Address: 33 Whitley Road Dewsbury WF12 0LP

Application number: 2021/91709	
What is the application for?:	Alterations to private driveway to create additional parking space via suspended
Address of the site or building:	35, Whitley Road, Thornhill, Dewsbury, WF12 0LP
Postcode:	WF10 3HP

TITLE:
PROPOSED CAR PORT
EXISTING & PROPOSED PLANS

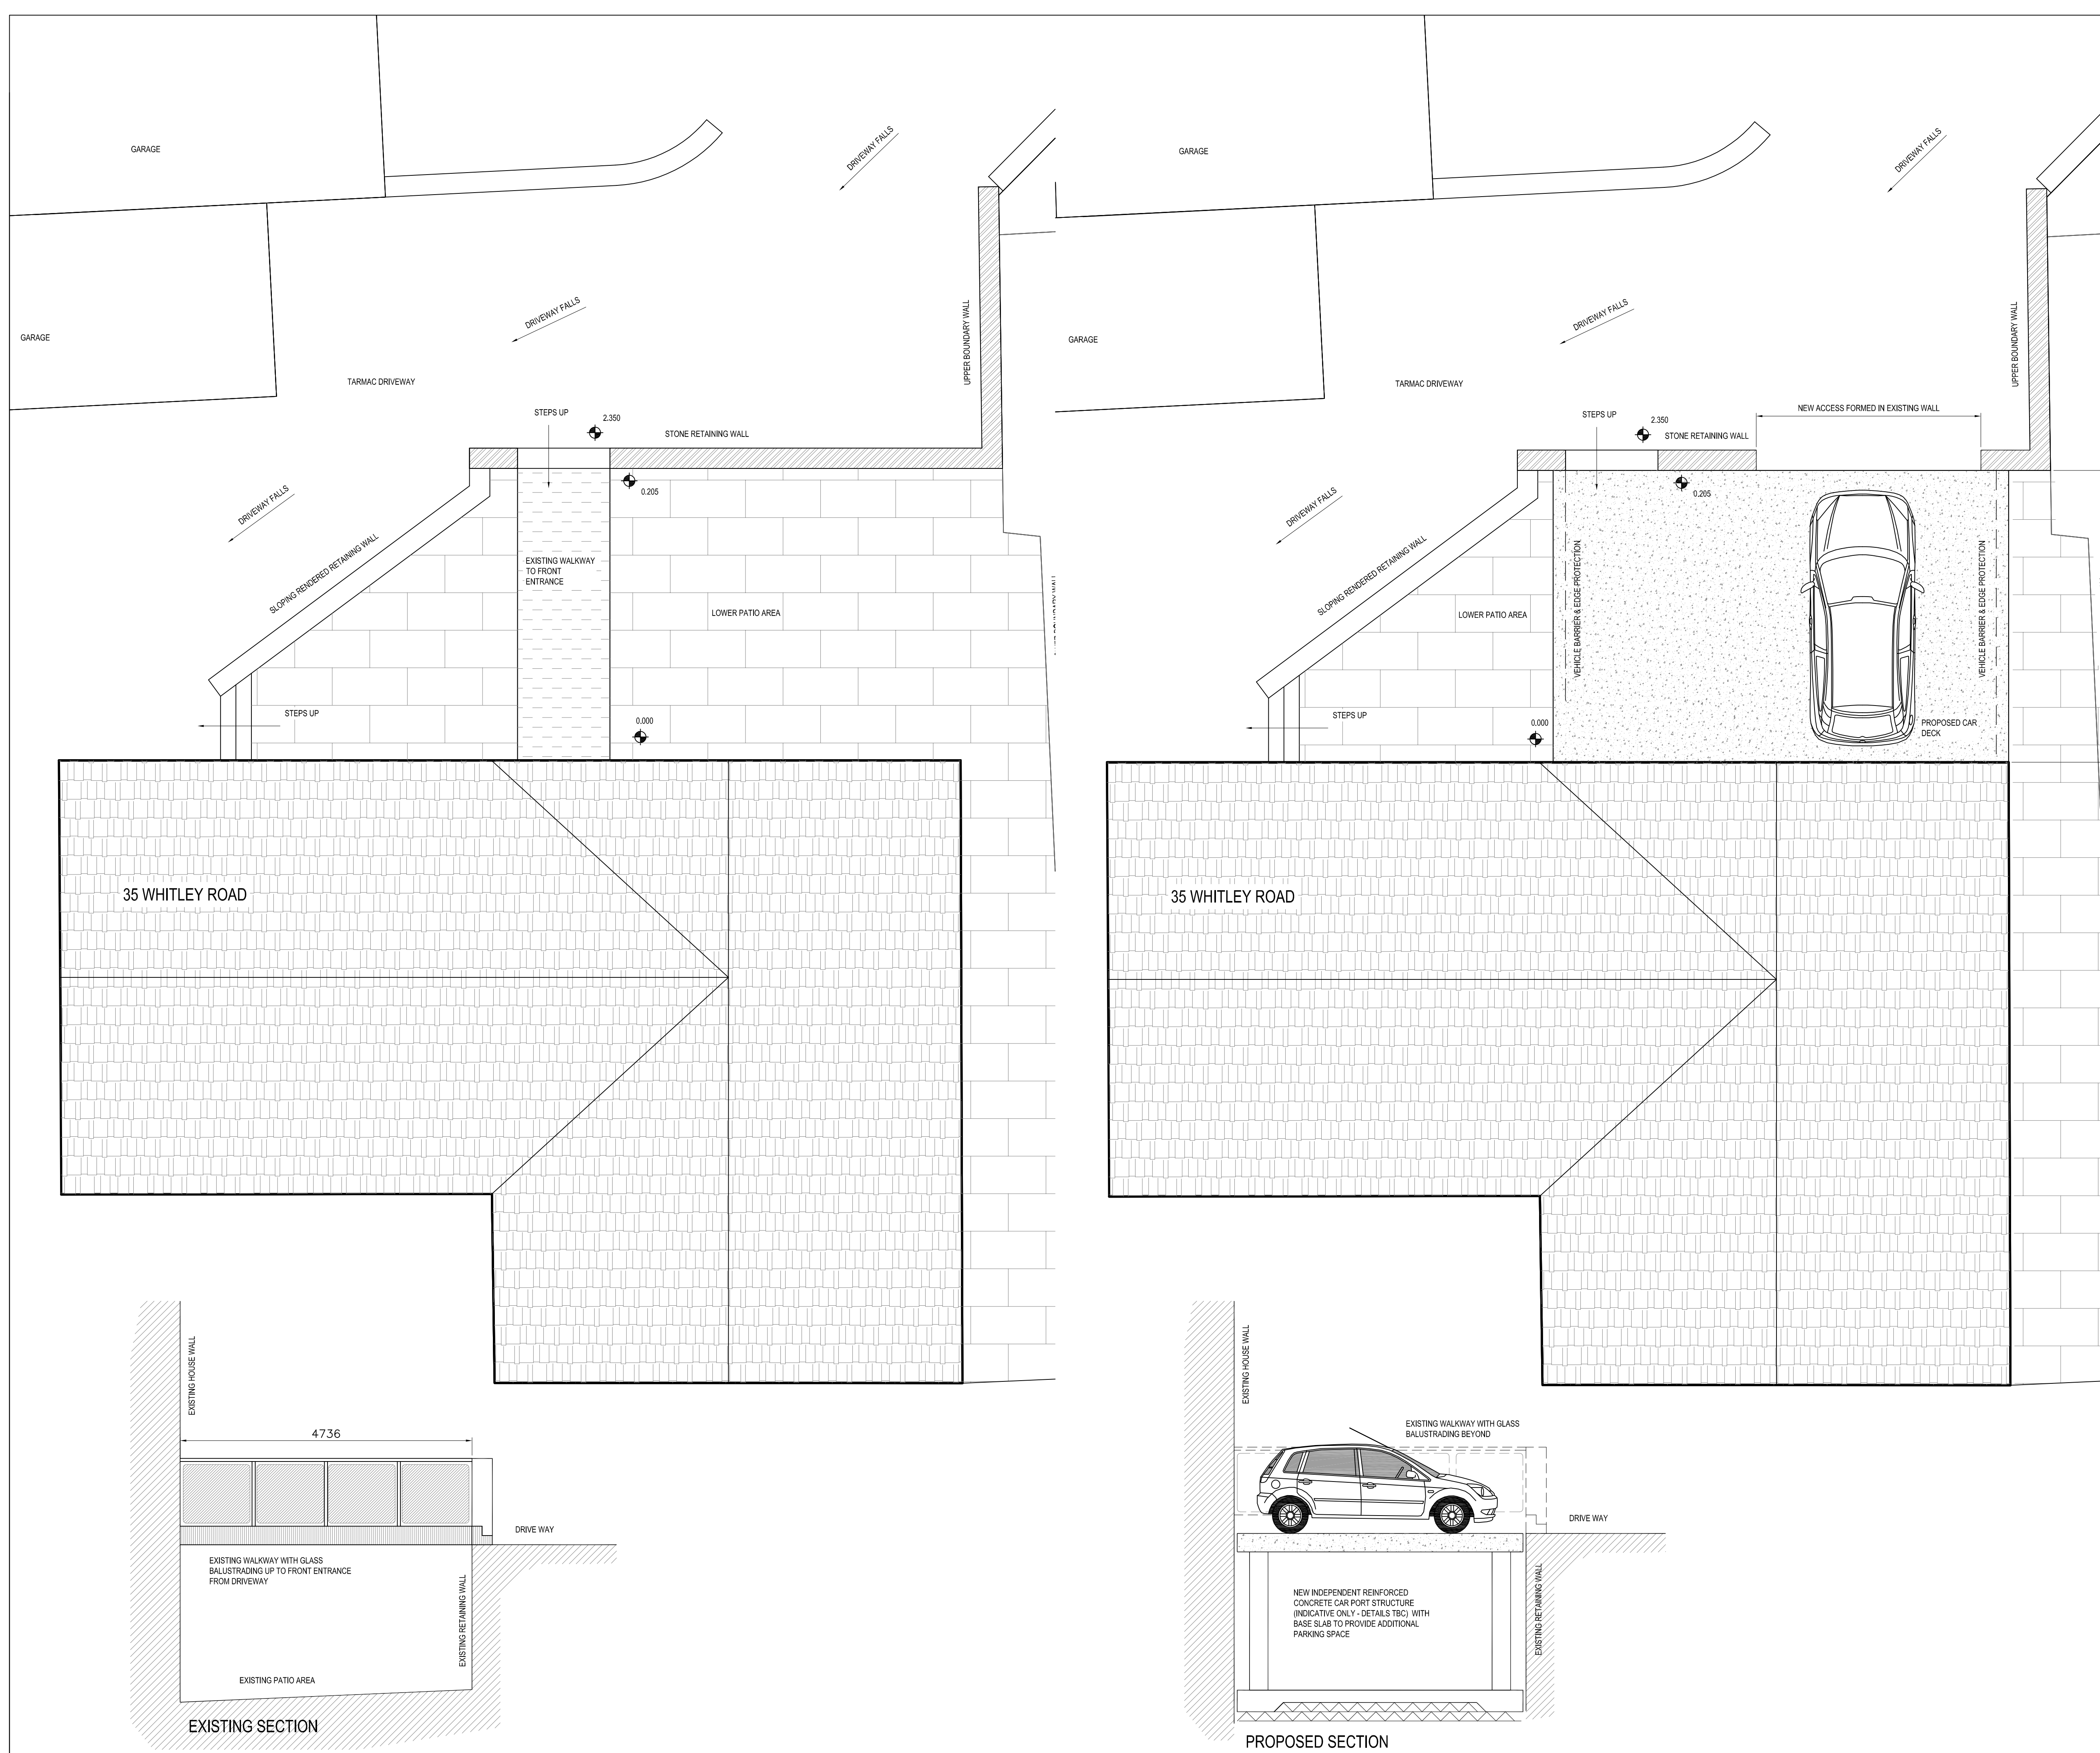
Type of comment: A general comment	
Do you wish your comments to be published on the website anonymously?	No
We are the neighbouring property to the proposed suspended driveway. We would like to make comments specifically with regards to safety standards, given that the structure that will be suspended above our property access . We would like to be reassured that the proposed will comply with all regulatory and safety standards and that planners will look at the plans and scales from a neighbouring orientation. In addition we would like to understand what the structure will look like aesthetically and what size it will be and or any impact it might impose to us due to it's proximity to our property access
